Application No: EP/57/20/HH  
Site Address: 32 Vermont Drive East Preston West Sussex BN16 1LA  
Description of works: Loft conversion with side dormer and hip to gable extension to rear.

Thank you for your internet representation made on 6th July 2020 which has been recorded as an objection with the comments as follows:

PROPOSED FIRST FLOOR PROPOSED 1ST FLOOR PLAN + SECTION

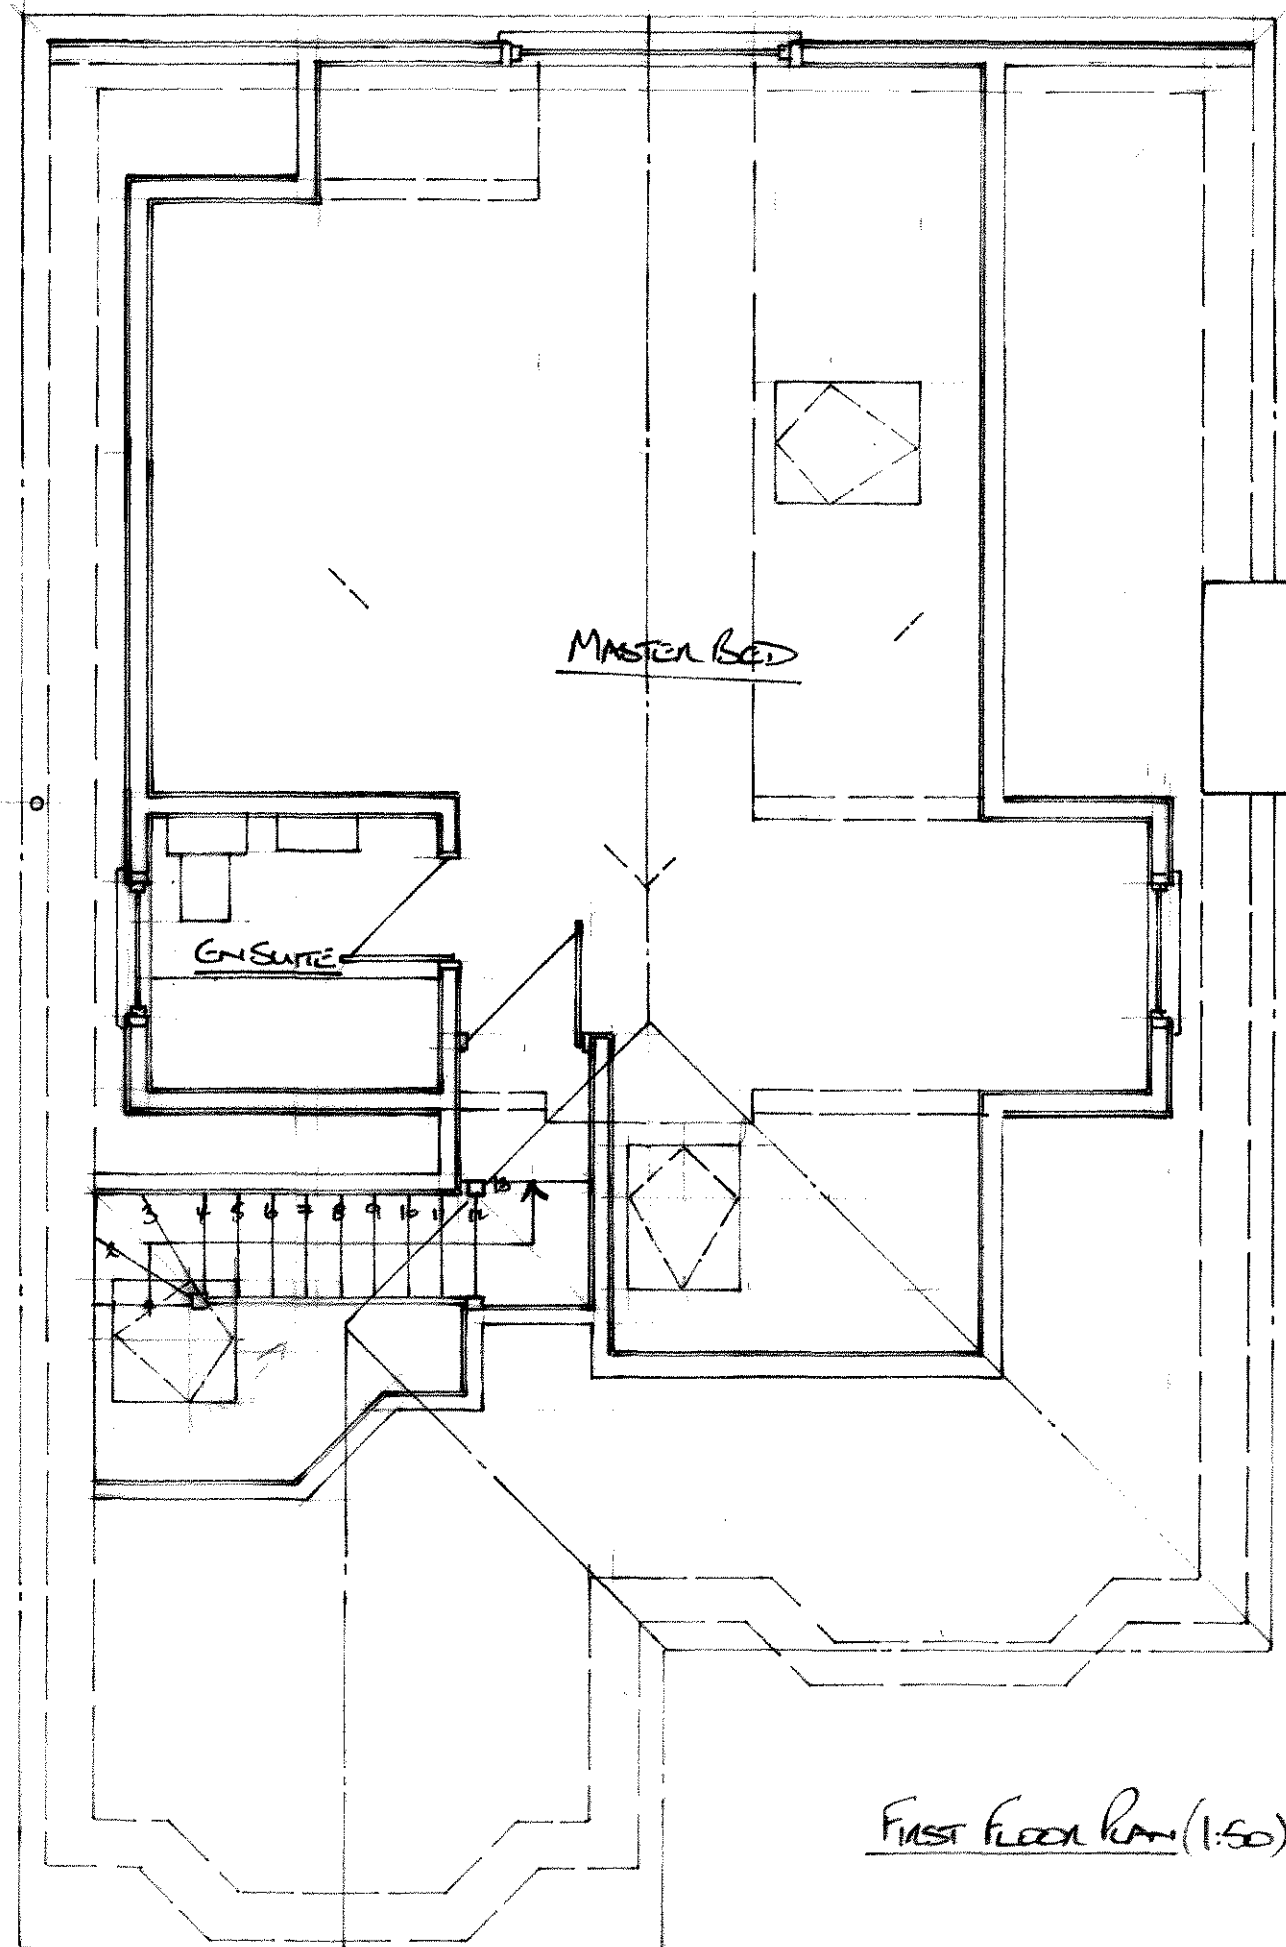
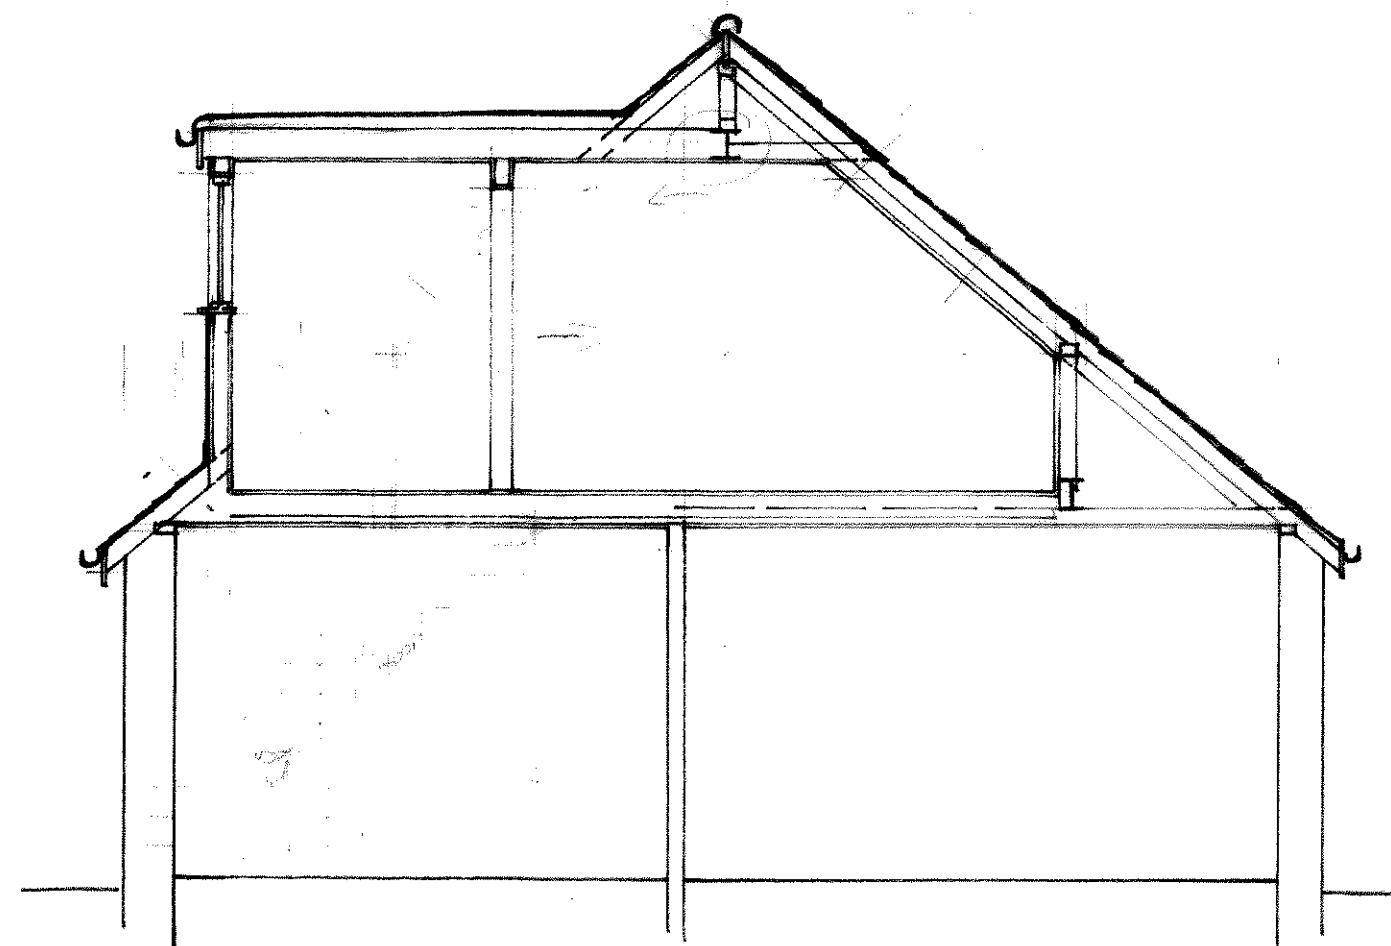
The window with views in the hip to gable extension would reduce privacy in every North facing room and the back gardens of at least 5 properties in the Nookery. Our property would be the most most devastatingly exposed. The window in the hip should not be allowed in its current form. It would preferably be removed from the plan. As a minimum it should only be permitted with obscured glass.

The distance between the properties being a mere 15m the proposed first floor window in the Southern extension (hip to gable end) will loom over our back garden. It will destroy what feeling we have of outdoor privacy (already very little for a 4 bedroom chalet bungalow of character) and look straight in to our kitchen dining room with double doors and rear bedroom window This will be exacerbated by the fact that the garden and building at 32 Vermont Drive are built on land that is higher than our property.

PROPOSED FRONT ELEVATION (1:100)

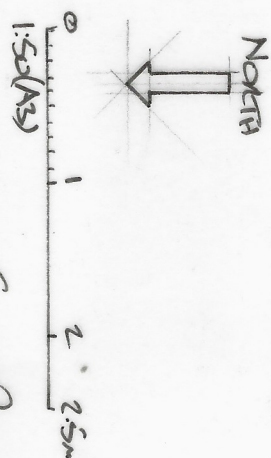
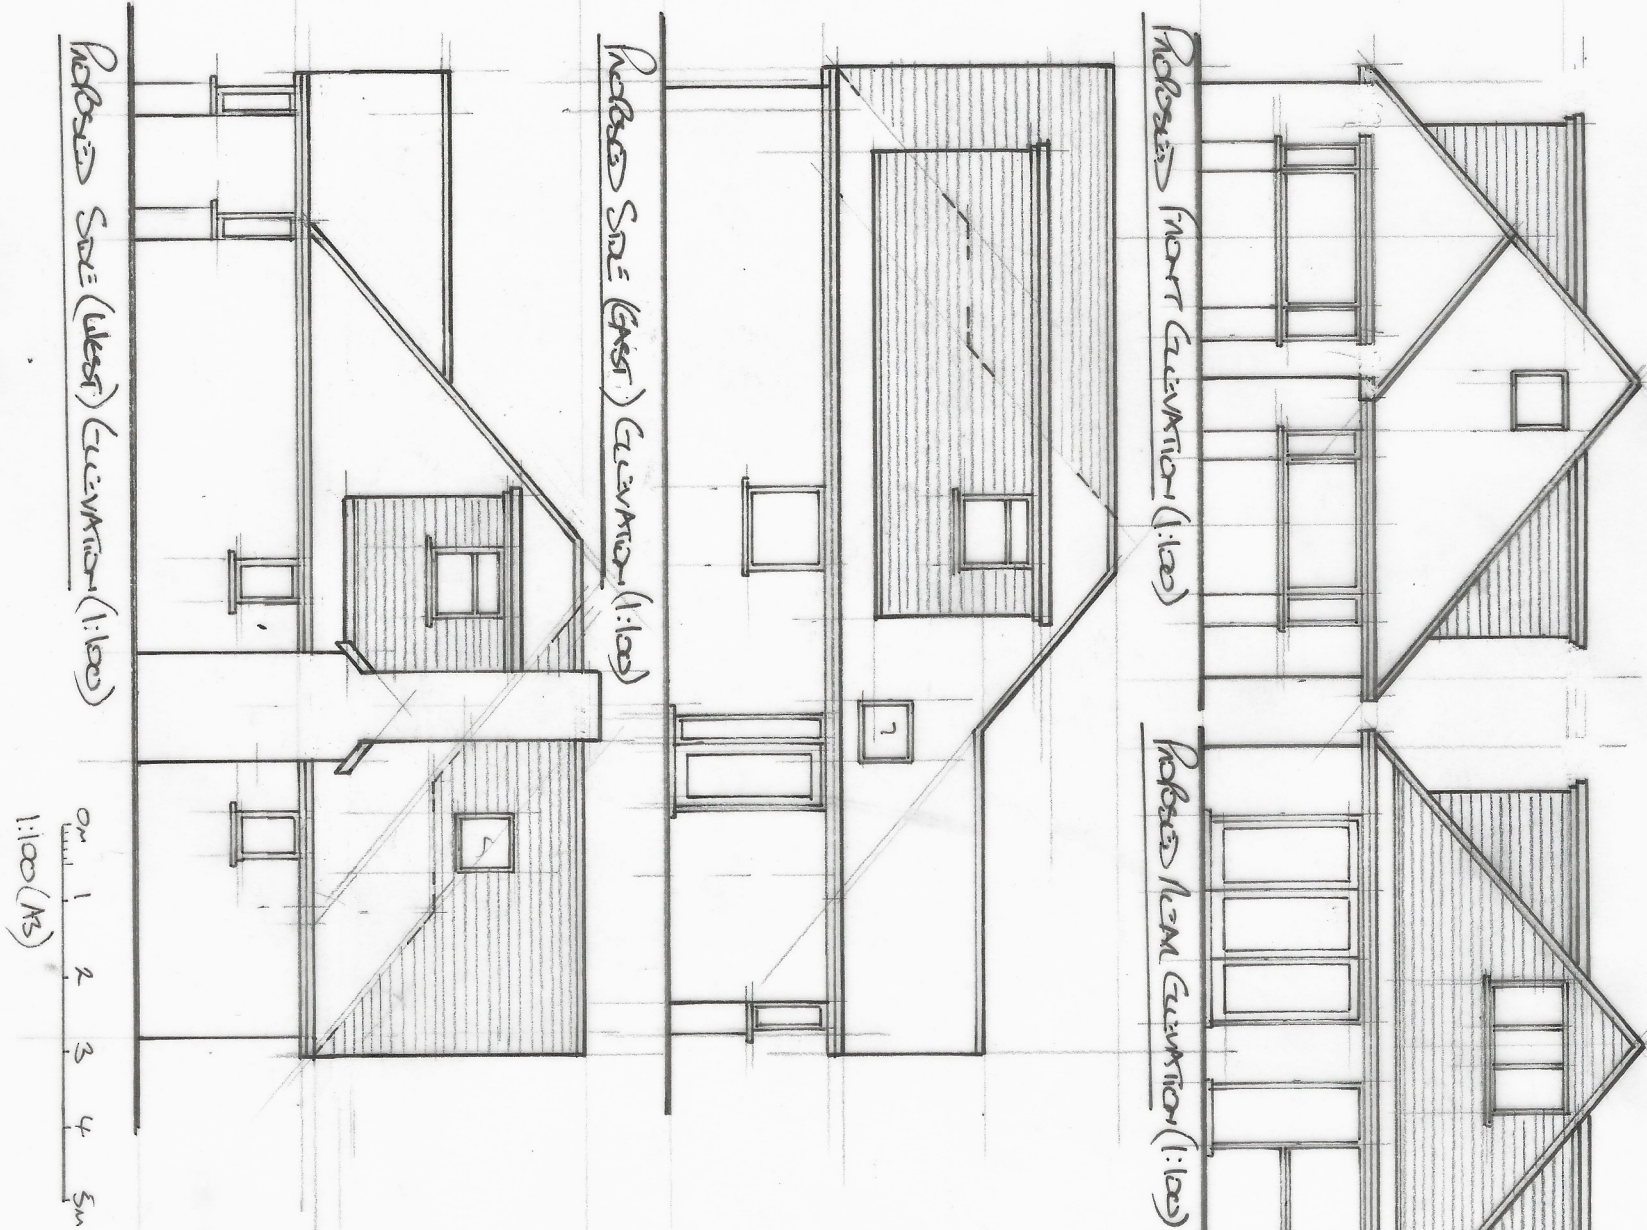
The dormer windows are also subject to Policy 1 of the Neighbourhood plan which states in paragraph 4.14 "rooms in the roof space may be permitted if the dormer windows are small enough to be subservient to the appearance of the roof as a whole". Plans of the front and rear elevations both show that the proposed dormers, 1 to the East and 1 to the West would not be subservient to the appearance of the roof.

**SUMMARY** The proposed hip Extension would be overbearing in relation to my garden. The proposed window in the hip extension would involve a great loss of privacy to several households. The proposed dormers to either side are not subservient to the appearance of the roof as a whole with its low pitch.
